DELEGATED DECISION

Item No.	Report of the Interim Director of Planning, Regeneration & Public Realm	
Address:	7A HIGH ROAD ICKENHAM	
Development:	Construction of a two storey building to provide a commercial unit (Class E) and 1 self-contained residential unit (Class C3) with associated refuse and cycle storage and provision of an undercroft.	
LBH Ref Nos:	77708/APP/2022/3645	
Drawing Nos:	P9/001 Rev A P9/002 Rev A P9/003 Rev A P9/008 Rev A P9/005 Rev A P9/006 Rev A P9/007 Rev A P9/004 Rev A	
Date Plans received:	04-01-23	Date(s) of Amendments(s):
Date Application valid	04-01-23

PROPOSED GROUND FLOOR PLAN - 1:100

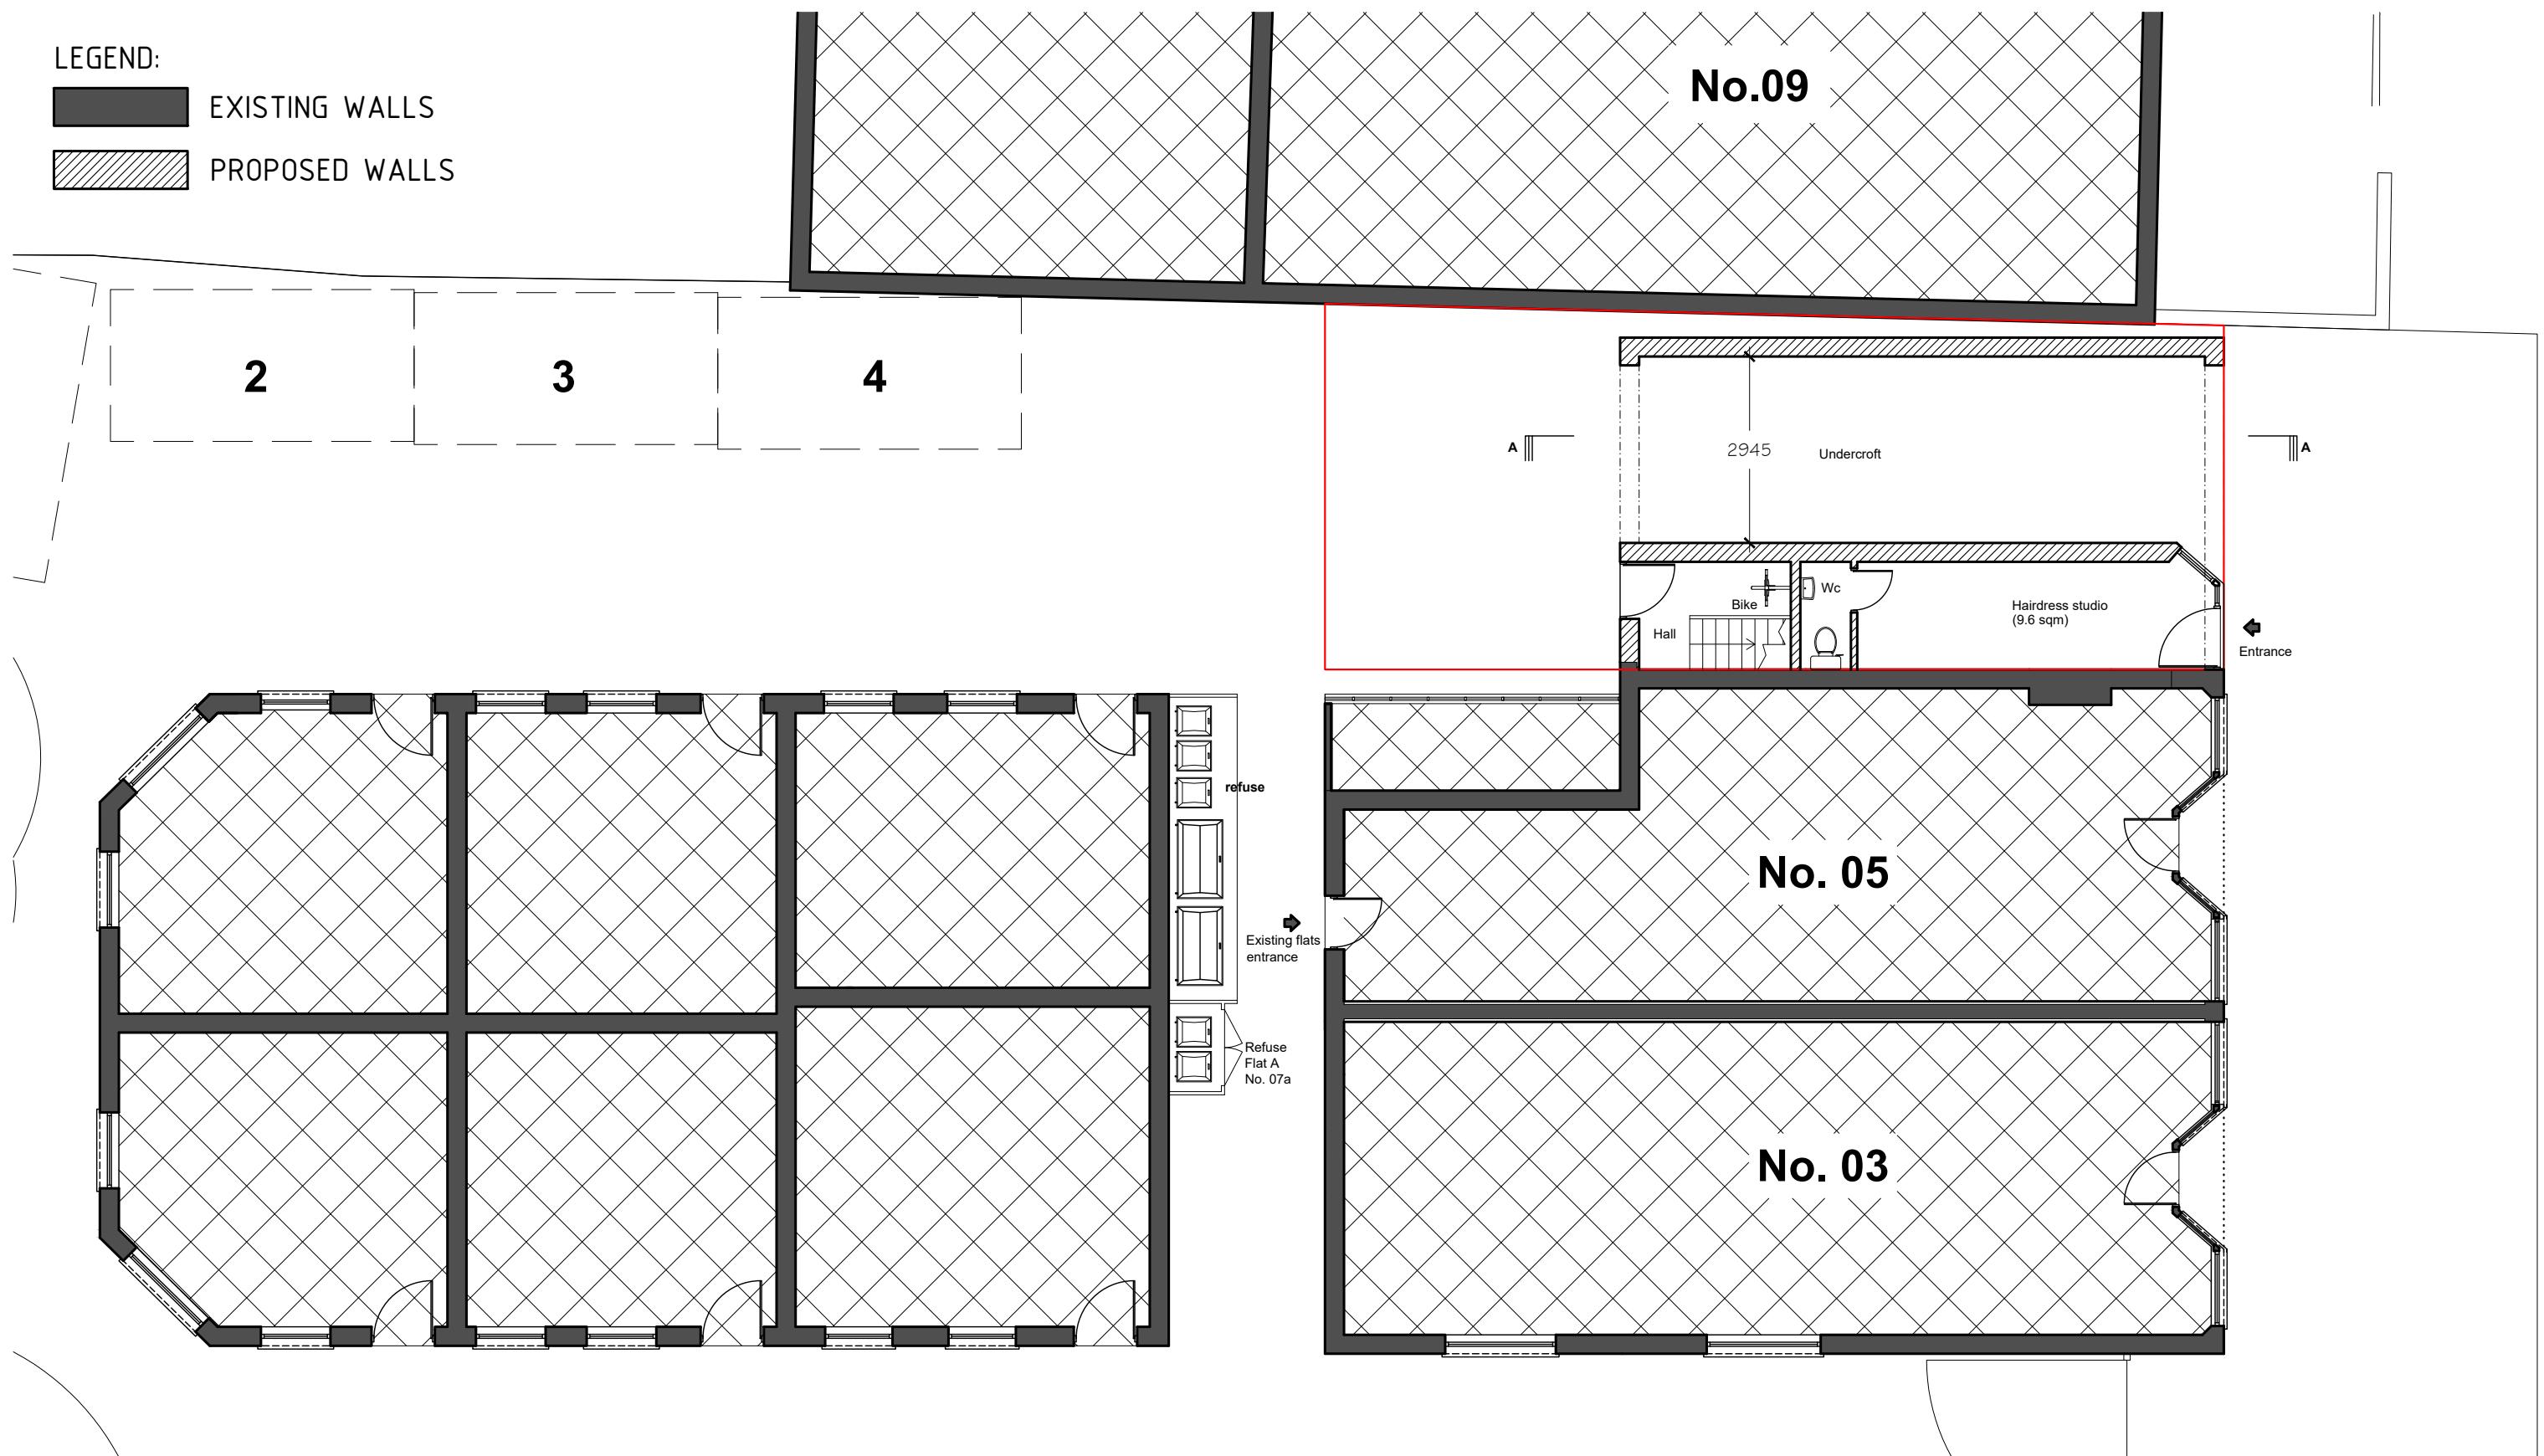
appeal decision. The subject application now includes a 2m wide retail frontage to the 5m width, which is a positive benefit. However, much like the loss of the gap, the creation of any vehicular access within the design would result in an incongruous addition which would disrupt the architectural character of the conservation area and the balanced composition of the original pair. It is recognised that the building to the north has an underpass. However, it forms part of a separate building and is not a feature that should be replicated. It is not supported on this basis and forms part of Reason for Refusal 1.

Although the access width is sufficient for emergency access (such as fire tenders), the 2.315m height will prejudice physical access. Where a fire tender cannot, for whatever reason, gain access into a site, fire appliances should be able to be positioned within 45m of the source of an emergency in order to execute their duty. In line with Building Regulations, if this distance is exceeded then alternative options such as hydrants and or internal water sprinkler systems can be applied in lieu of a fire tender accessing a site thereby covering all eventualities. Henceforth if, in this particular case, fire tender access is not achievable through the access road, the aforementioned distance parameter as set by Building Regulations would be met. On this basis, no objection is raised.

PROPOSED FIRST FLOOR PLAN - 1:100

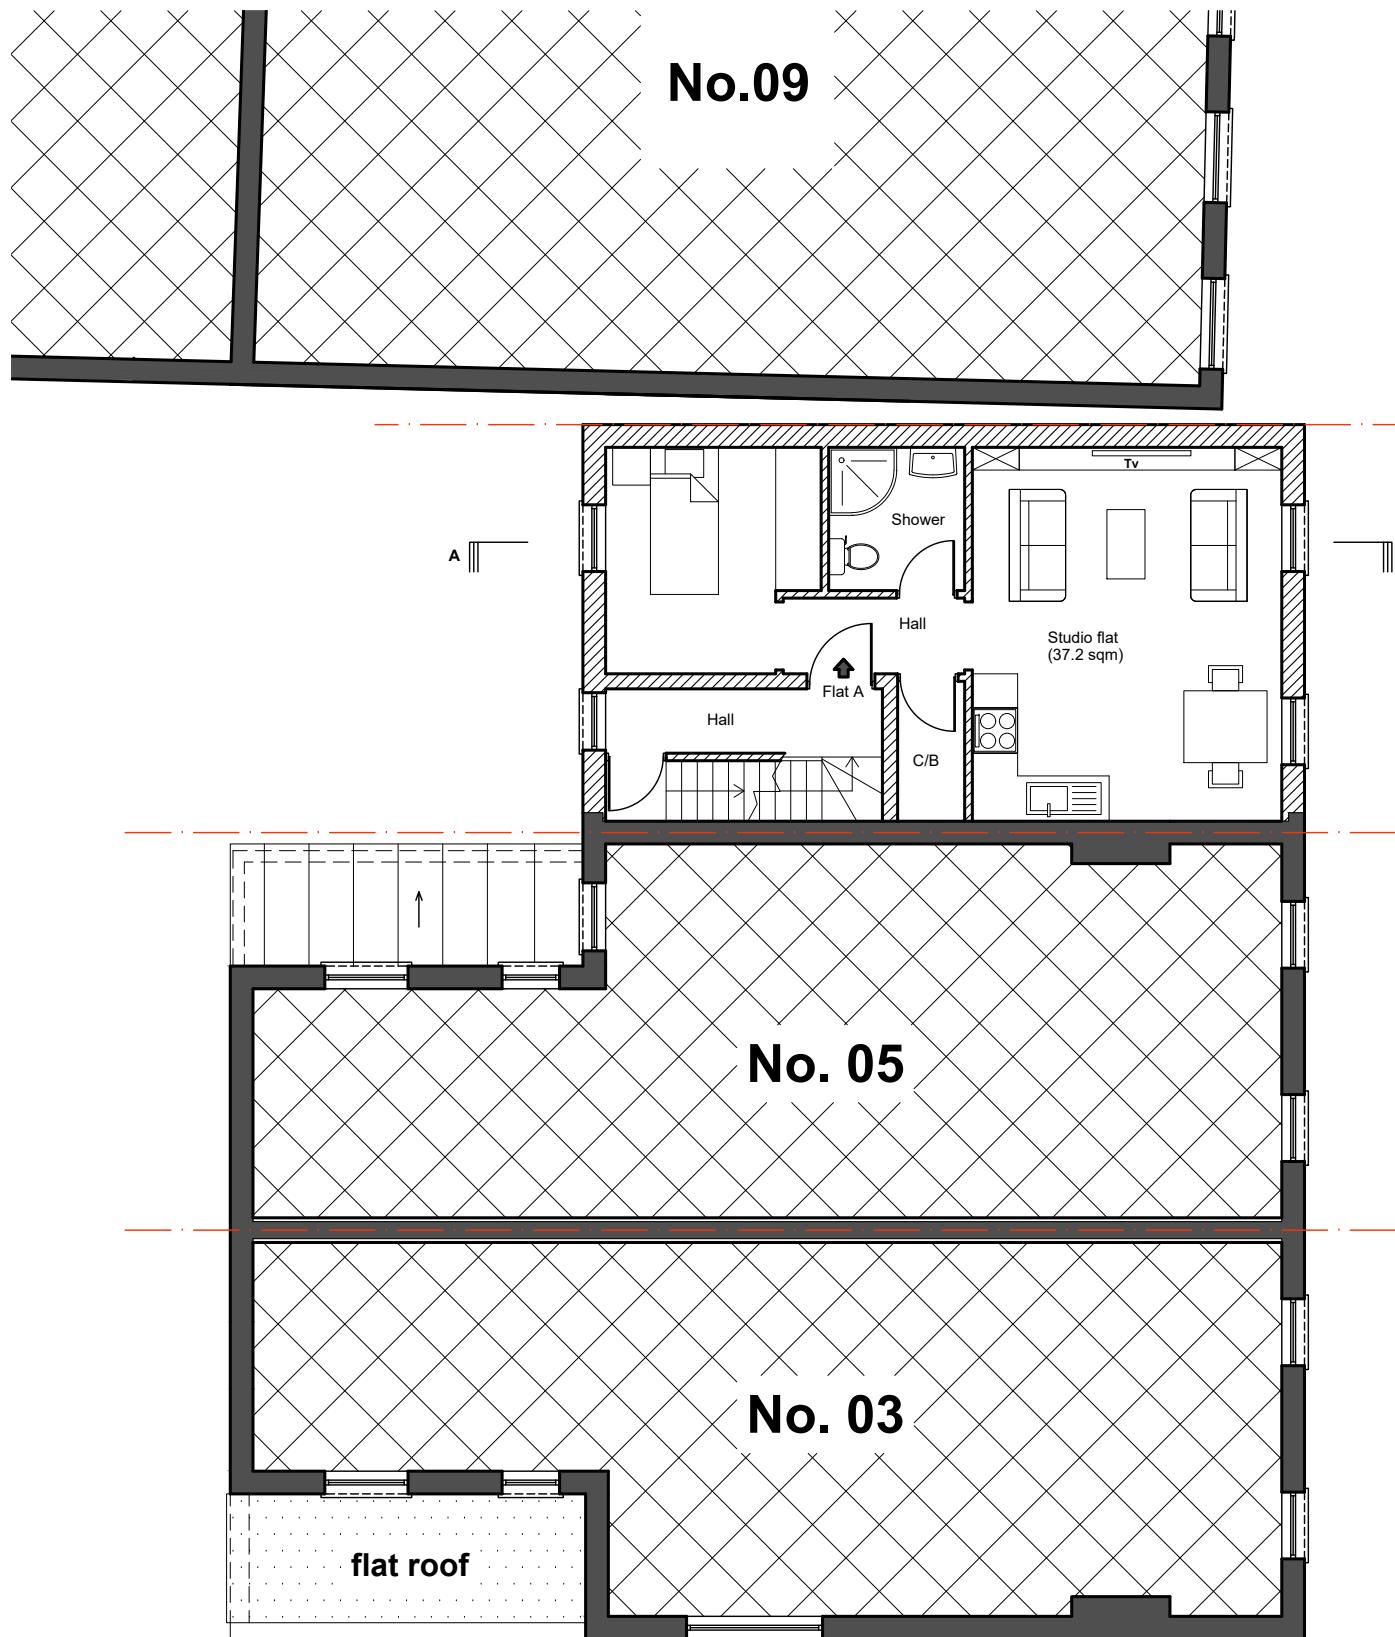
Policy DMHB 16 of the Local Plan require a minimum internal space standard of at least 37m² for a 1 bed, 1 person occupancy unit without a bathroom (at 7.5m², the bedroom is single occupancy). The unit has an internal floorspace of 44m² which accords with the minimum requirement. There is dual aspect to the unit with living spaces to the eastern elevation, which provides for good outlook and cross ventilation.

Policy DMHB 18 specifies a minimum outdoor area of 20m² for a studio unit where none is proposed. Given the circumstances of the subject site (above an access), the small scale of the unit (studio) and the surrounding area (an office conversion to the rear without any external amenity space) and as no objection was raised with the previous application on these grounds, there is no objection with this application.

PROPOSED FRONT ELEVATION - 1:100

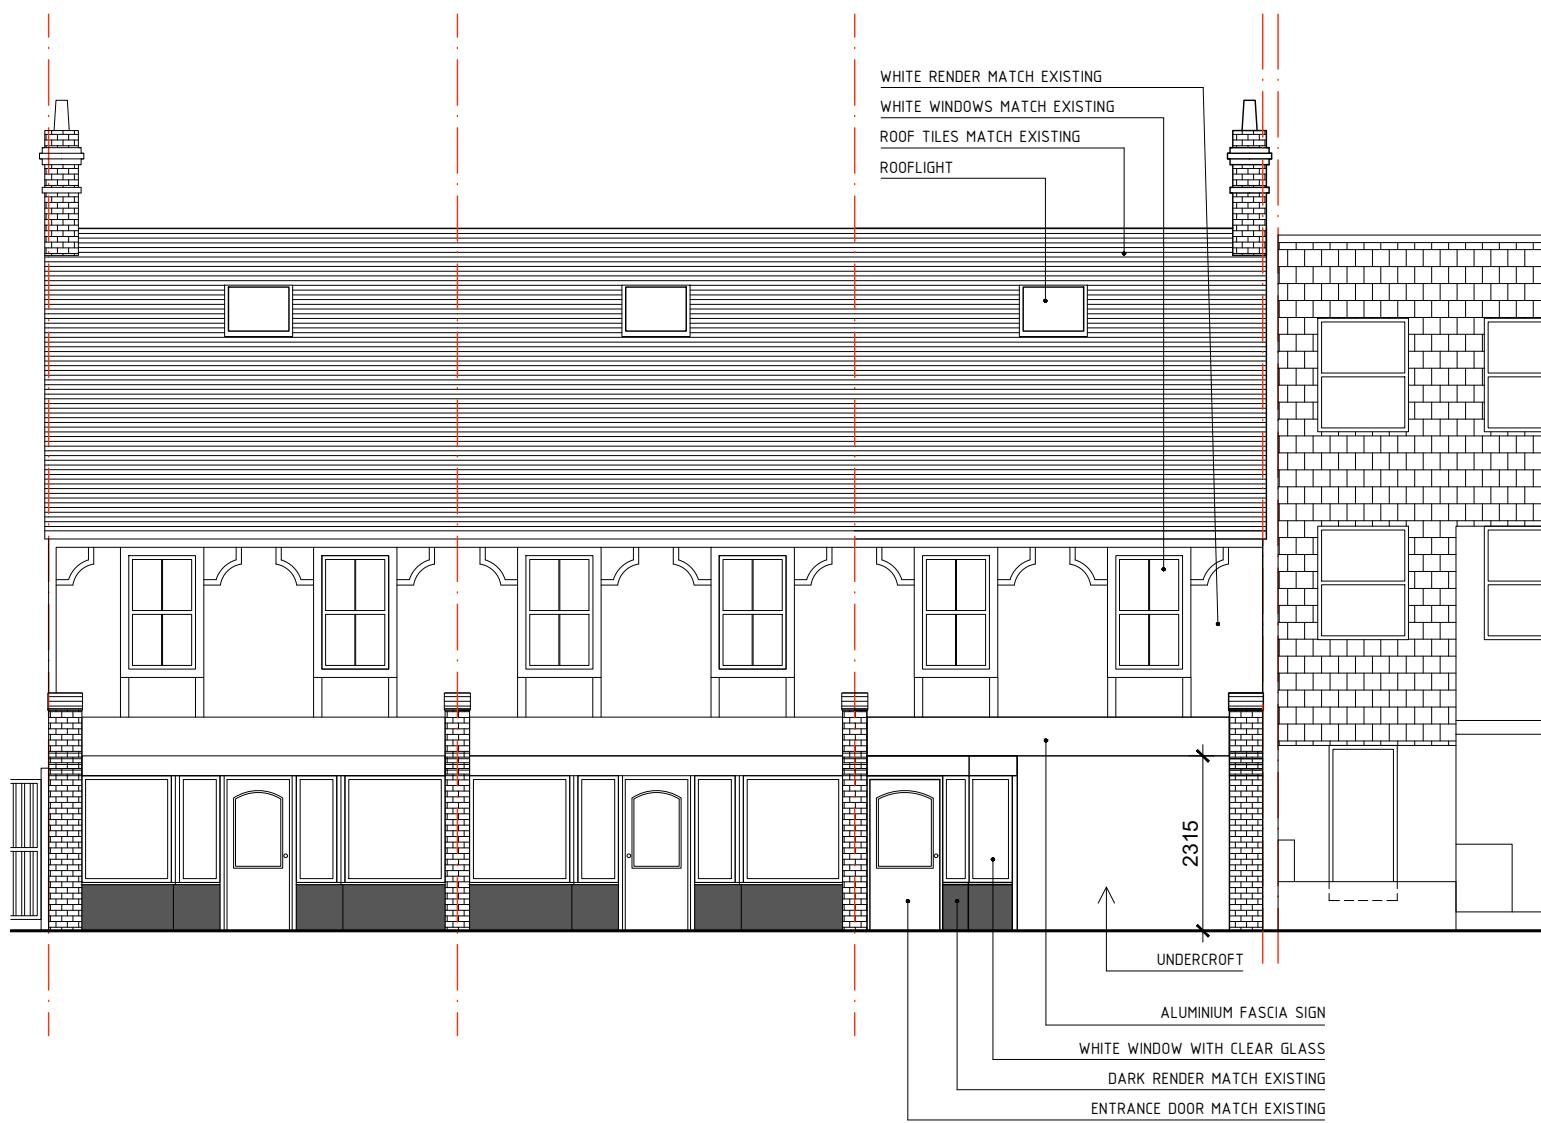
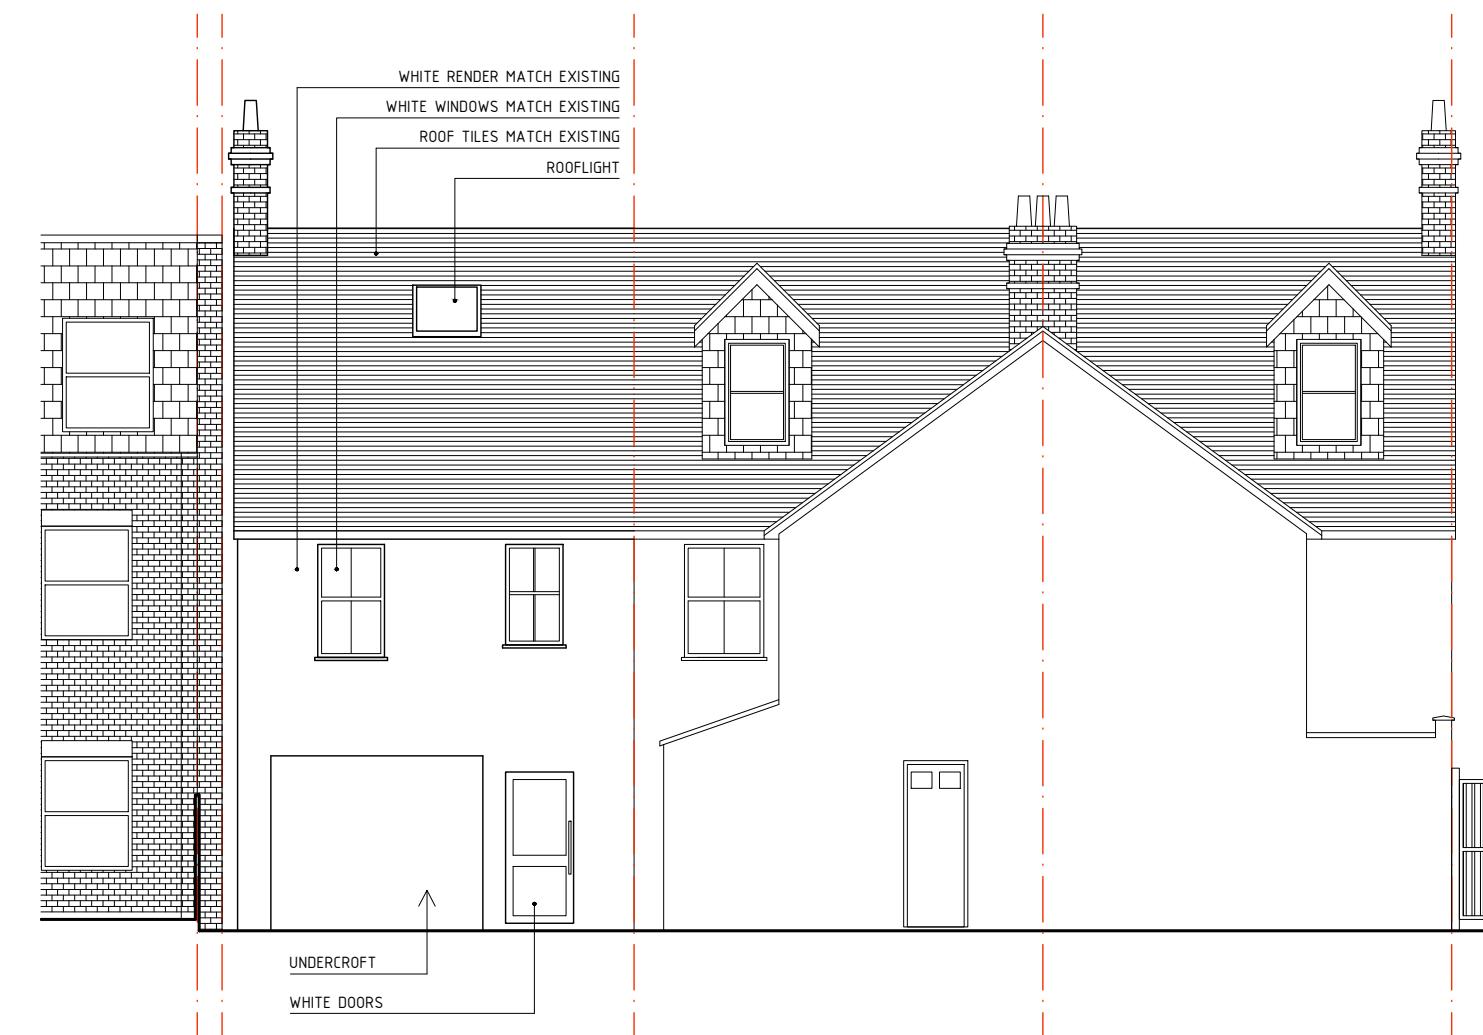
By infilling the building gap with 7 High Road to the north, the development results in the loss of openness and building separation that is a characteristic of this part of the conservation area. It also comprises an incongruous underpass/tunnel feature which is incompatible with the existing semi detached building. Collectively, these two aspects of the development pose less than substantial but unacceptable harm to the setting and character of the Ickenham Village Conservation Area. When weighing the public benefits, the proposal is contrary to Section 66 of the Planning (Listed Buildings and Conservation Areas) Act 1990, Section 16 of the National Planning Policy Framework 2021, Policies D8 and HC1 of the London Plan 2021, Policy BE1 of the Hillingdon Local Plan Part One 2012 and Policies DMHB 11, DMHB 12 and DMHB 4 of the Hillingdon Local Plan: Part Two 2020.

The changes made since the most recent refusal and dismissed appeal resolve the Inspector's concerns relating to the perception of being a visually obtrusive development. Indeed, the symmetry and continuation in building form are positive outcomes. However, the Inspector is fairly clear at paragraph 8 that the infilling of a gap is of significant damage to the conservation area. The proposal would still involve the loss of the gap or rhythm to properties in the street and despite changes to the underpass tunnel, it would still appear as an incongruous feature.

This part of the conservation area is characterised by a degree of openness and building separation with views between buildings of a leafy backdrop. Any development would bring about a loss of openness and impression of building separation and in effect, the principle of the development cannot be overcome. The loss of the gap would fail to enhance and/or preserve the character and appearance of the Conservation Area and is not supported as outlined in Reason for Refusal 1.
